Cinders Lane Nursey

Planning Reference Y/4/19/RES

Approval of reserved matters following outline consent Y/5/17/OUT

Yapton Parish Council (YPC) has given careful consideration to the above application which outlines the detail of the 51 residential units at Cinders Lane. This proposal forms part of Yapton Neighbourhood Plan's housing contribution to the ALP.

HOUSE TYPE 2 | PLANS & ELEVATION
DEVELOPMENT AT:
CINDERS LANE
YAPTON

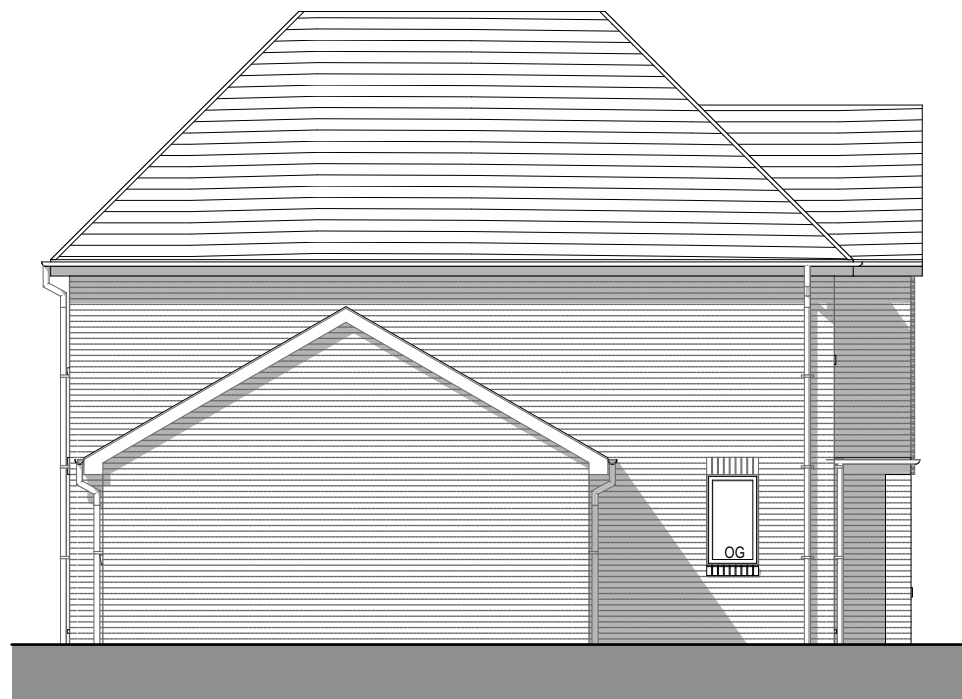
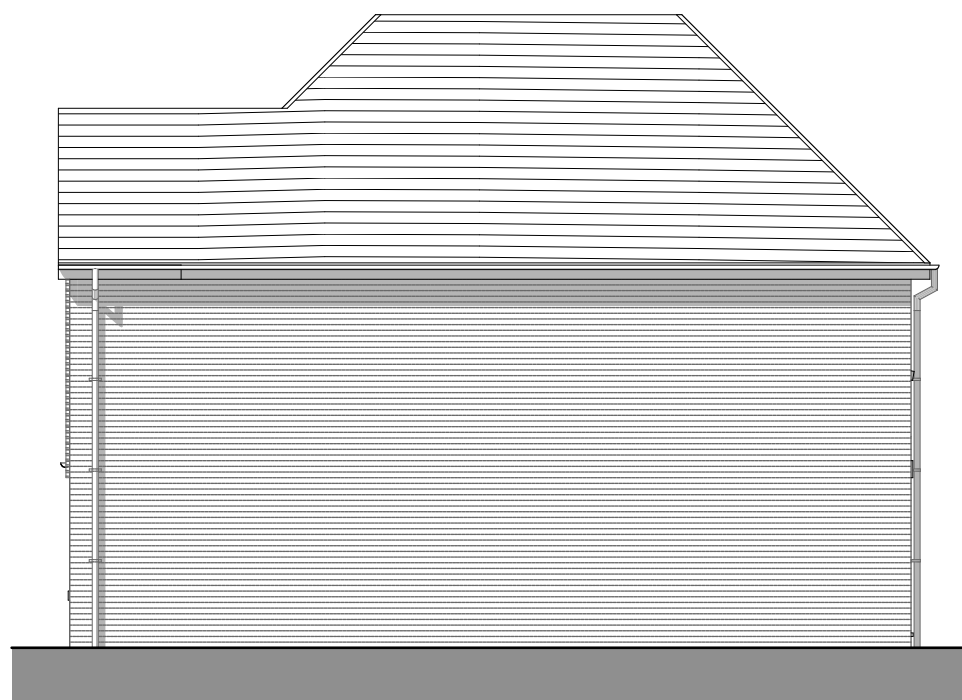
Whilst YPC appreciate that the applicant has tried to use brick relief to present some variation in appearance YPC believe that on the scale of 51 units this is lost and a bland urban streetscape is being proposed. YPC would request that a more varied approach to use of materials should be applied as per the new Emerald Gardens, a

more recently completed scheme in the Parish. The scheme needs to reflect the overall village's heritage and reinforce the Parish's heritage through a mix of materials including flint and hanging tiles.

YPC therefore would request that the suggested brick palette is varied with the use of flint and clay tiles throughout the scheme ensuring a scheme more identifiable with an Arun coastal Plain village.

SITE LAYOUT | SERVICES PLAN (1 of 1)
DEVELOPMENT AT:
CINDERS LANE
YAPTON
BN18 0JJ
FOR
CRAYFERN HOMES LIMITED
Scale :1:300 @ A1 Date : June 2019
Drawing No : 19.14.107

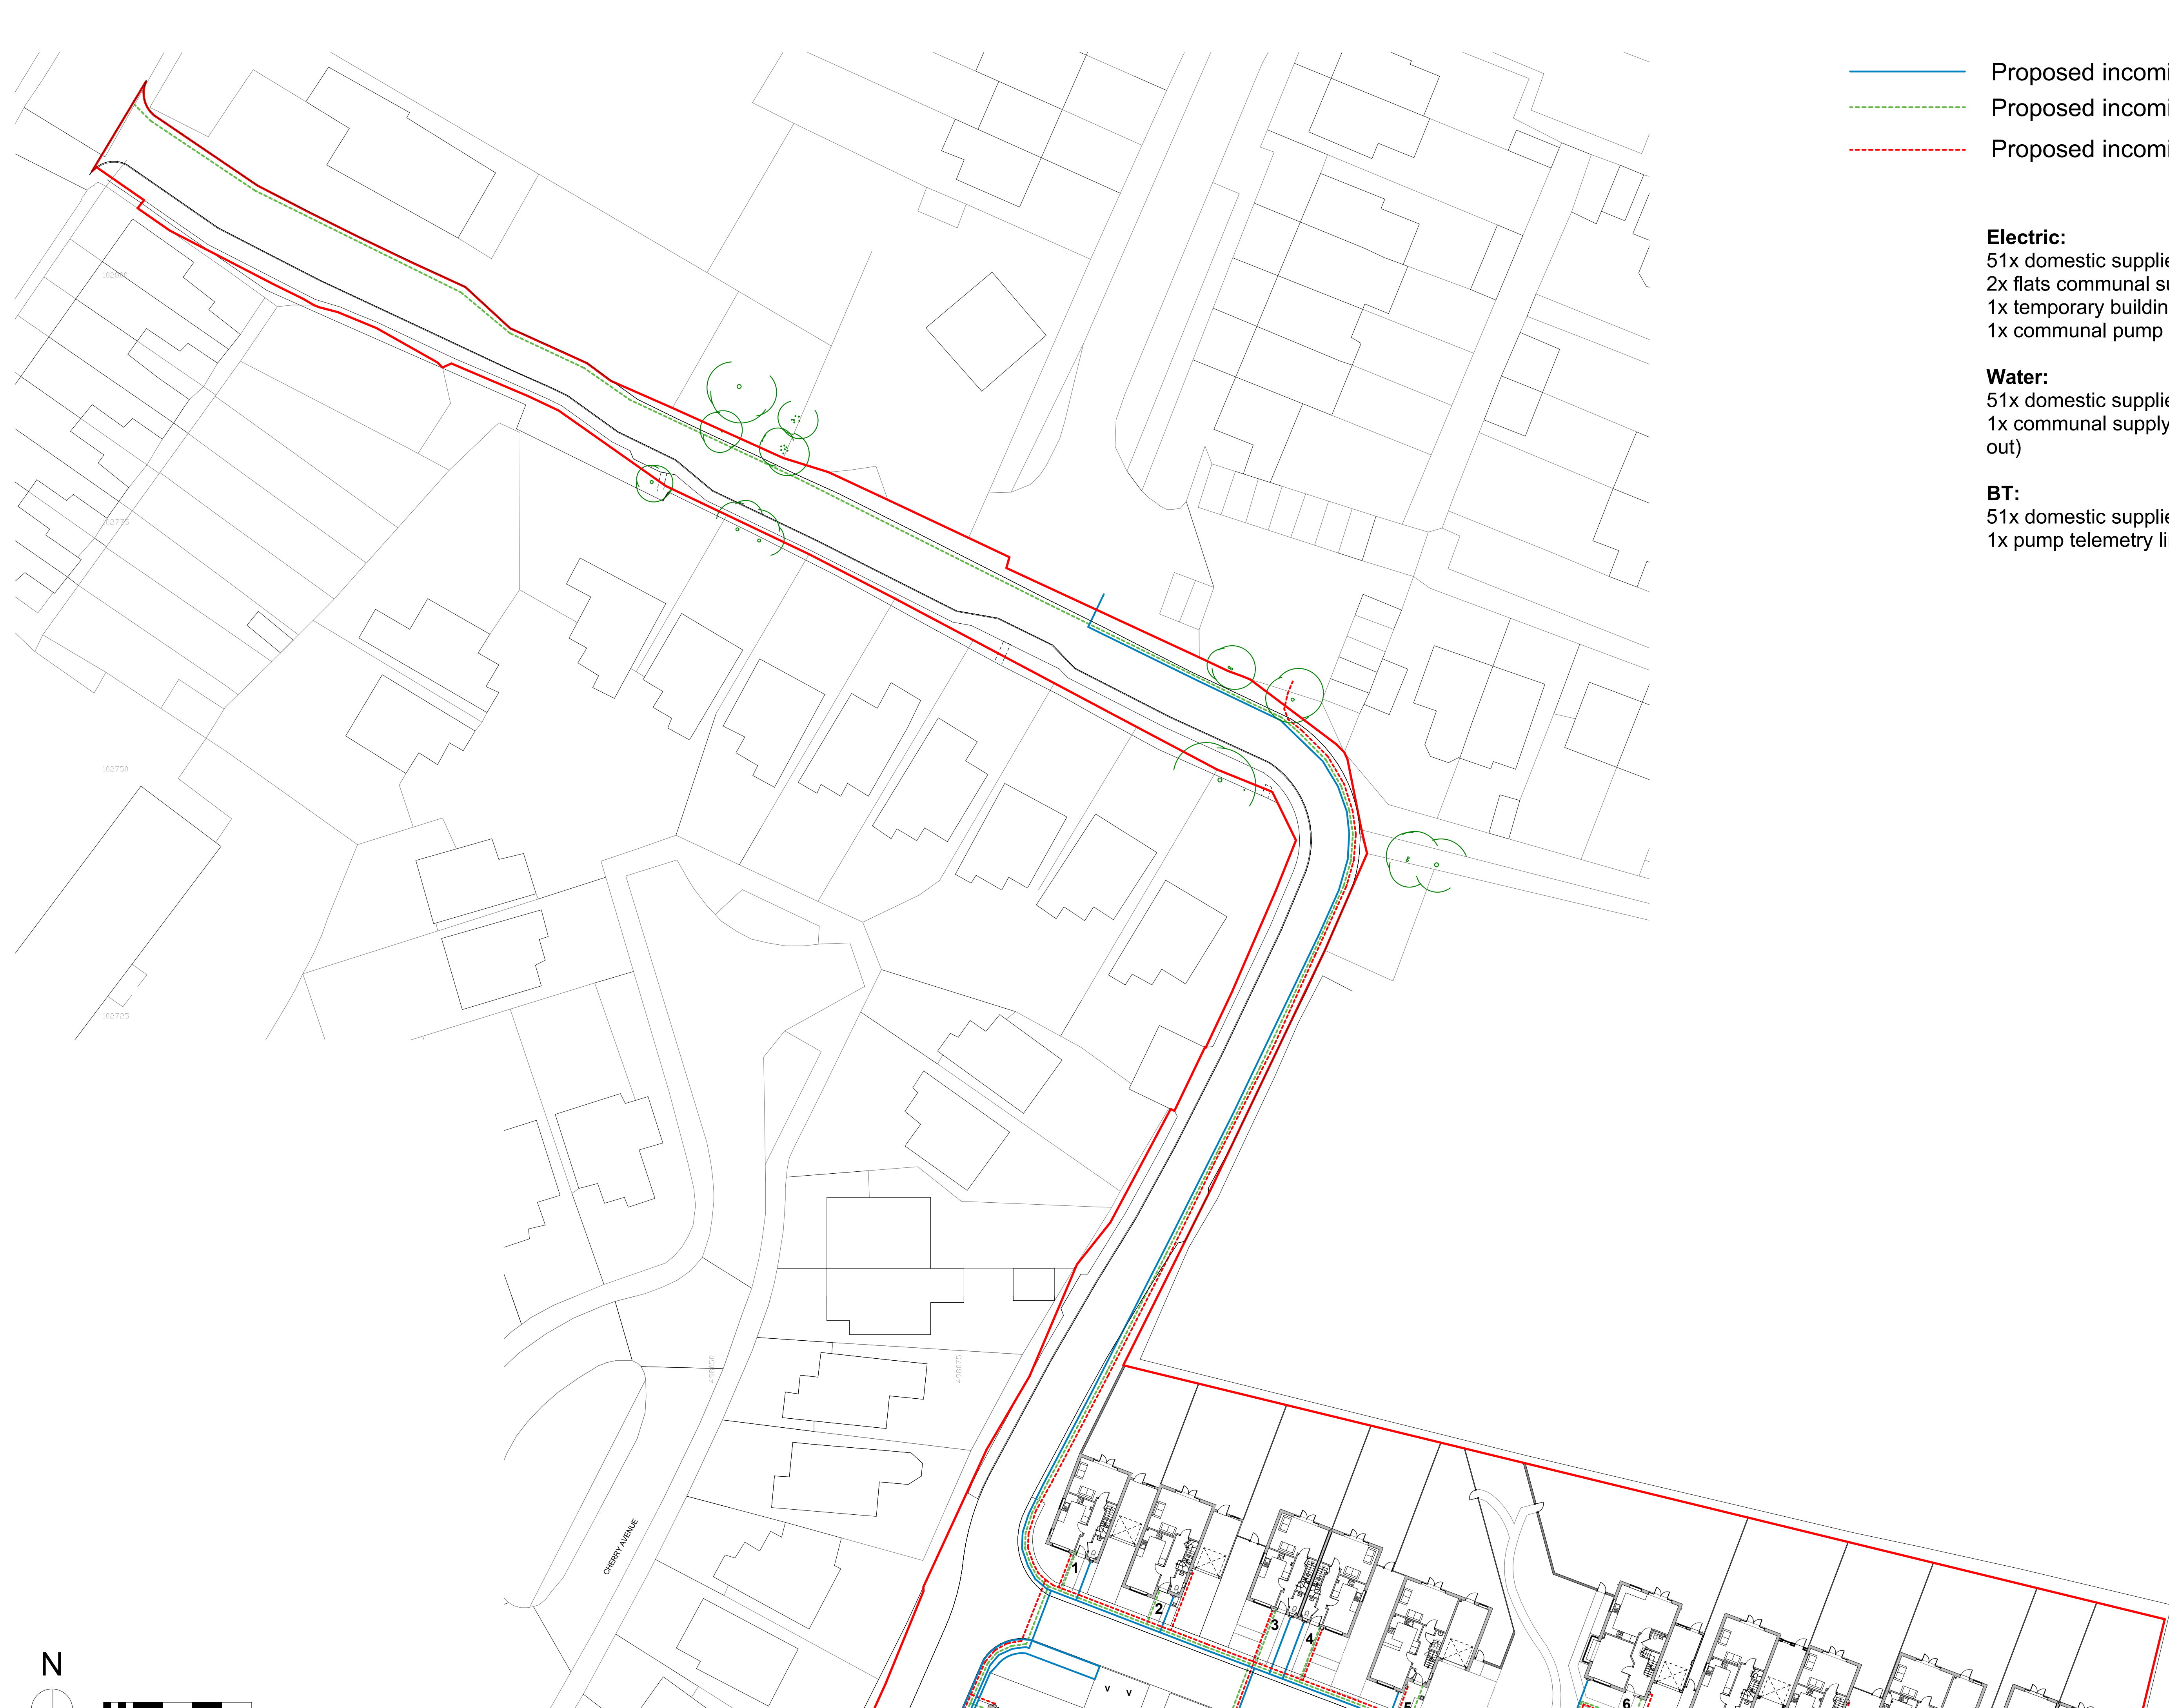
YPC would also seek that the designated visitor parking area and spaces fronting residential units is softened by the use of CORE Grass or similar green permeable parking system. This would maintain the practicality of hard landscaping for parking areas but provide a softer finish providing a more rural outlook onto green space opposed to tarmac/block paving.

YPC seek to ensure that the footpath along the eastern edge of the proposed site is upgraded to being able to accommodate multi-use. In doing this, the path must have adequate useable width to ensure its safe use by all especially for passing. The path

is currently at a suggested 3m width and YPC would recommend that this is increased to a minimum useable width of 5m to ensure that the existing landscaping/hedging is accounted for and does not encroach into the multi-use pathway and reduce its actual useable width.

YPC therefore require a condition that will specify the proposed public right of way be a 5m multi-user path built to an appropriate specification for immediate use after the first occupation of the scheme. Landscaping of the path must reflect the rural backdrop with adequate buffers/margins to ensure good biodiversity along the improved public multi-user pathway. This would help enrich the local environment and enhance Yapton's rural backdrop and residents of both the new housing and existing wellbeing.
